APPENDIX A – SUBMISSIONS REGISTER

The following table includes all 57 submissions received in total during the public exhibition of SSD-8706 for Night Racing at Royal Randwick Racecourse, exhibited between Wednesday 26 May 2021 to Tuesday 22 June 2021.

Figure 21 Indicative layout for proposed temporary diesel generators and MSB

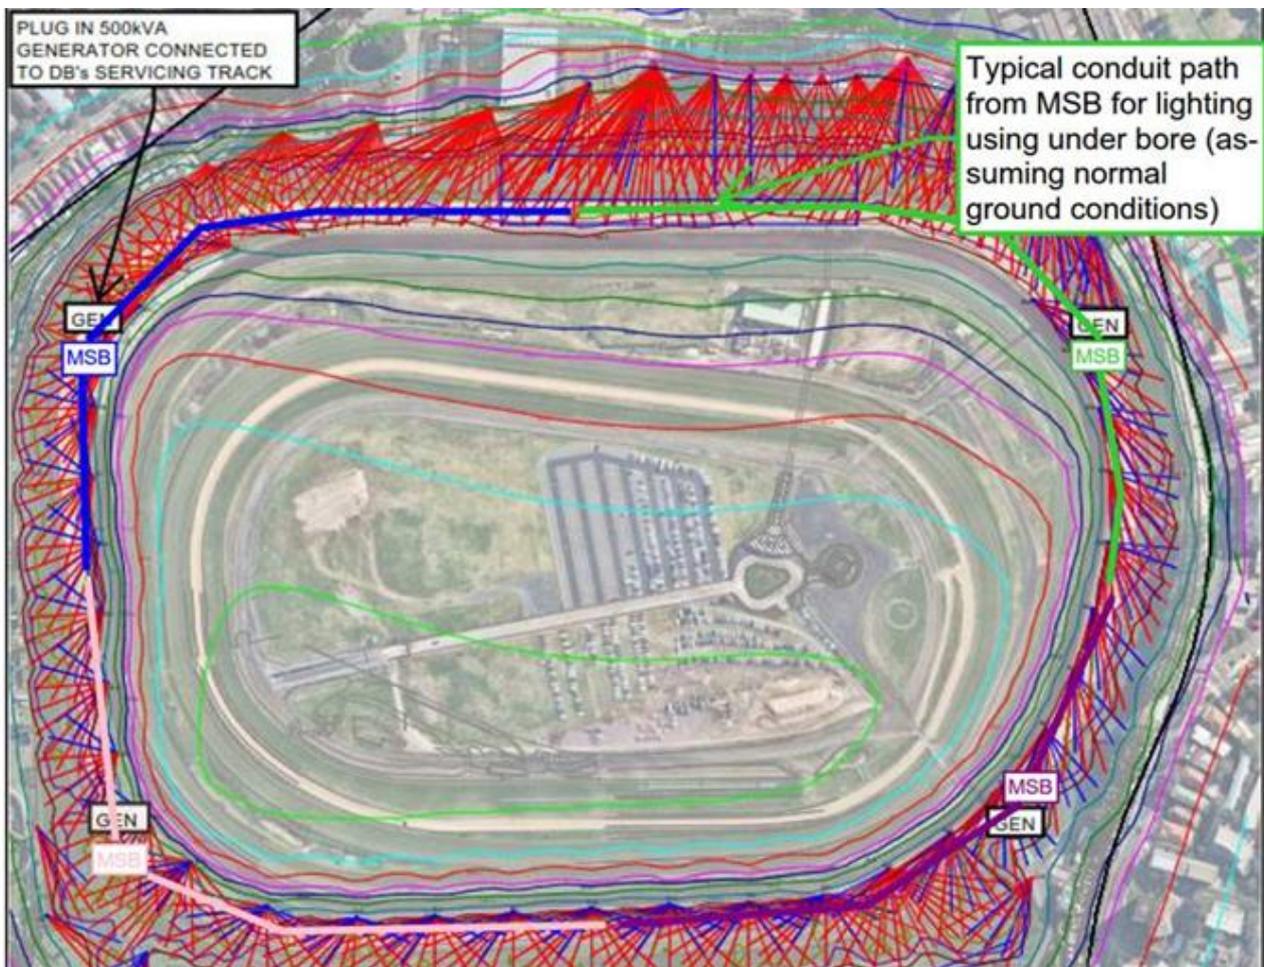
Mechanical Noise	<p>27. A number of the proposed four diesel generators are located within close proximity to residential properties. An acoustic assessment of the generators should be undertaken to assess potential noise impacts on nearby residents.</p>	Refer to Section 4.3.1
	Protection of significant trees	<p>28. Concerns are raised over the potential impact of the proposed lighting column locations on existing significant trees. The Visual and Landscape Impact Report prepared by Sturt Nobel and Associates identifies three lighting columns in close proximity to exceptionally significant trees and three columns located in close proximity to existing trees of high significance. Potential impacts have been identified including damage to tree roots and incursion into Tree Protection Zones (TPZ). The Report recommends that physical assessment should be re-reviewed in consultation with an arborist at detailed design stage. Further, the EIS states that the exact final location of columns may vary up to 10% due to arborists advice during detailed design.</p> <p>29. Council does not support the removal or substantial pruning of trees listed as significant under the Randwick Register of Significant Trees. As such, Council recommends that an Arboricultural Impact Assessment be undertaken as part of the SSD assessment and prior to the detailed design stage to ensure the proposal will not result in unacceptable impacts to Council's Register of Significant Trees.</p>	Refer to Section 4.3.7

Figure 22 Spectator precinct upgrade lighting upgrade layout

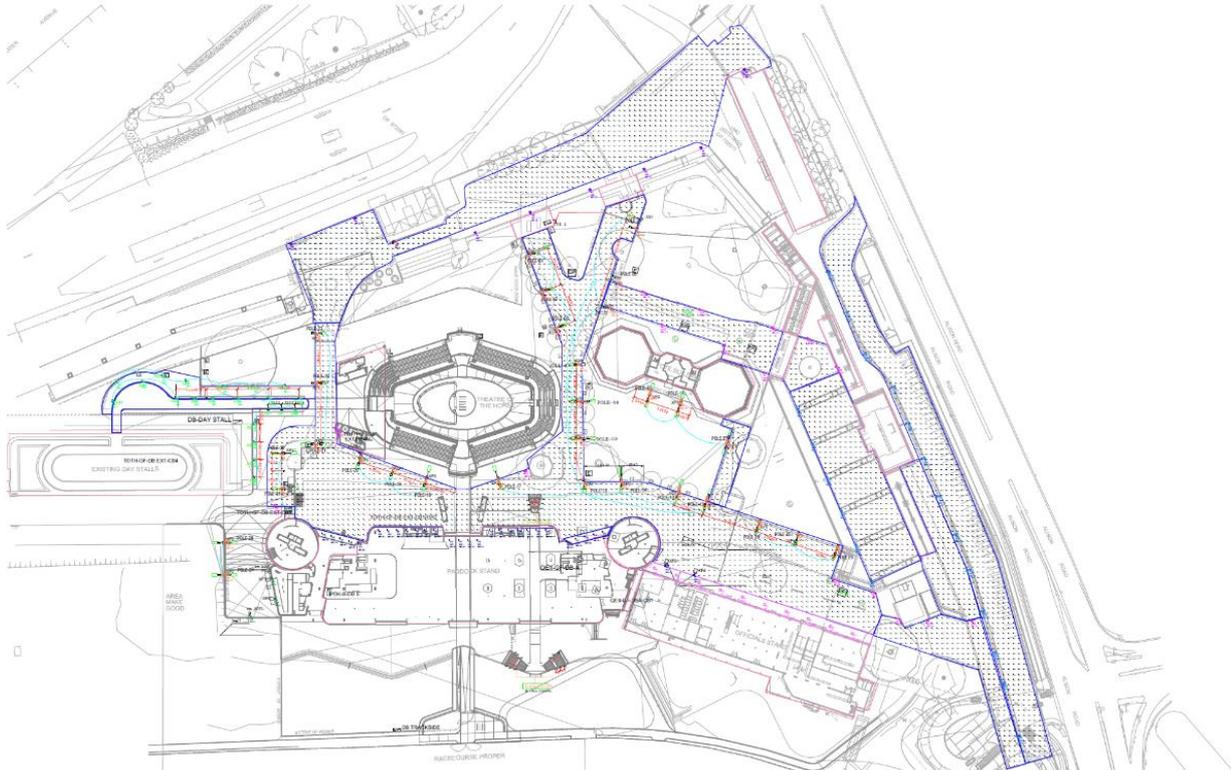
Lighting Design	<p>40. Consideration should be given to the potential impact on the nearby properties from the proposed upgrade of Spectator Precinct lighting. The layout of the proposed lighting is missing in submitted Lighting Assessment and the extract in the EIS is illegible.</p> <p>41. Council recommends a condition of consent requiring post installation adjustment of trackside and Spectator precinct lighting, to address any unacceptable light spill be found to adjoining properties.</p> <p>42. It is understood that trackside lighting levels have been designed to enable televised racing. However on occasions where racing is not televised, a lower level of lighting should be required to reduce unnecessary light spill impacts. Conditions should be recommended in this regard.</p> <p>43. The submitted EIS states that events will be concentrated between October and April to coincide with day light savings, reducing the hours required for lighting and therefore reducing the overall light spill impacts to adjoining properties. However, the EIS also states that flexibility is required to hold events outside of these months. Council recommends events be limited to between October and April to reduce the impacts of light spill to adjoining properties.</p>	Refer to Section 4.3.4

Figure 23: New Geometry of Doncaster Avenue / Ascot Street (Priority) Intersection

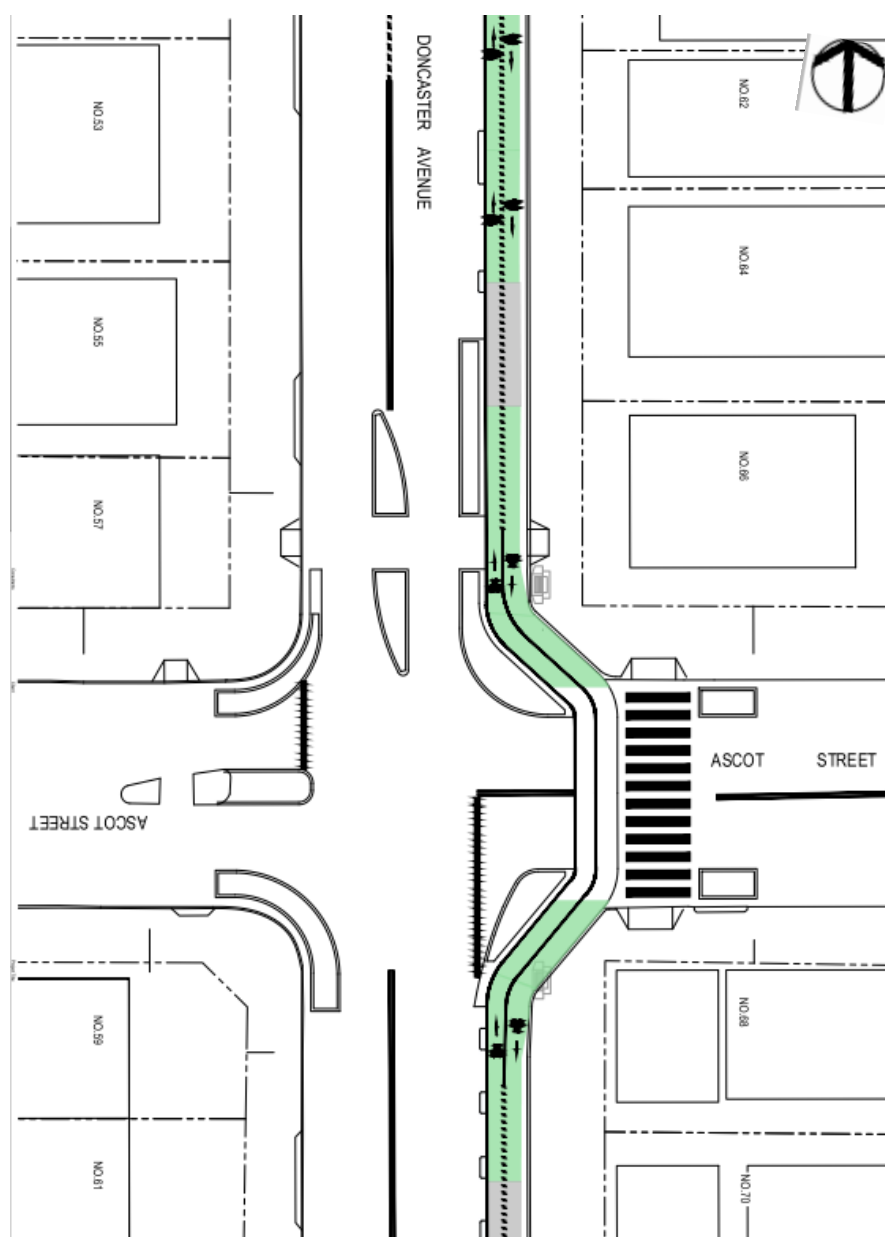
Transport and Parking	<p>16. Concerns are raised regarding the impact of private vehicle usage on the local street network. Council is aware that some patrons who drive to the RRR currently park in local streets and do not utilise the infield car park due to the time it takes to exit the car park at the conclusion of events. This leads to traffic and parking congestion in local streets surrounding the RRR. The submitted EIS and supporting documentation does not adequately address this issue. An assessment of parking impacts on the local road network should be undertaken to assess the impact of patrons parking in local streets.</p> <p>17. The signposting and enforcement of parking restrictions for (seemingly) random night-time race events will be very challenging. Council's previous experience with parking restrictions on 'Race Days Only' produced significant issues, as most Sydney residents do not know when race events are being held at RRR, nor should they be expected to. This has resulted in non-event motorists being issued with Parking Infringement Notices in the past.</p> <p>18. If residents or their visitors are not aware of night race events, they are likely to park in local streets, even if the street is signposted as '2P Residents Excepted, Race Days/Nights'. Additionally, Council considers night time parking restrictions imposed upon communities as an unacceptable burden, as it shifts the responsibility of parking management to individual residents and their visitors, rather than the venue operator. Further, the management of overflow night-time parking on local streets creates resourcing challenges for Council to manage night time restrictions</p> <p>19. There are strong concerns about the traffic impacts of the proposals. These concerns are supported by the SIDRA modelling contained within the submitted Traffic Impact Assessment. All of the key indicators arising from the modelling of Class 2 (up to 15,000 patrons) and Class 3 (up to 10,000 patrons) events under both operating scenarios result in significant increases in each of the critical SIDRA indicators, including major increases in Delays, Degree of Saturation and 95th Percentile Back of Queue Distances.</p> <p>20. Such major increases in these SIDRA indicators, in a neighbourhood where many of the existing intersections are currently performing with a Level of Service of F, is unacceptable. The overlay of the additional event traffic onto a neighbourhood with traffic flows currently performing poorly, will create major delays, congestion and subsequent frustration for the event and non-event community.</p> <p>21. The acceptance within the Traffic Impact Assessment (page 37) that modelling shows extension to delays in the network around the majority of intersections surrounding the RRR is particularly concerning, especially within a local network already under traffic stress.</p>	Refer to Section 4.3.2
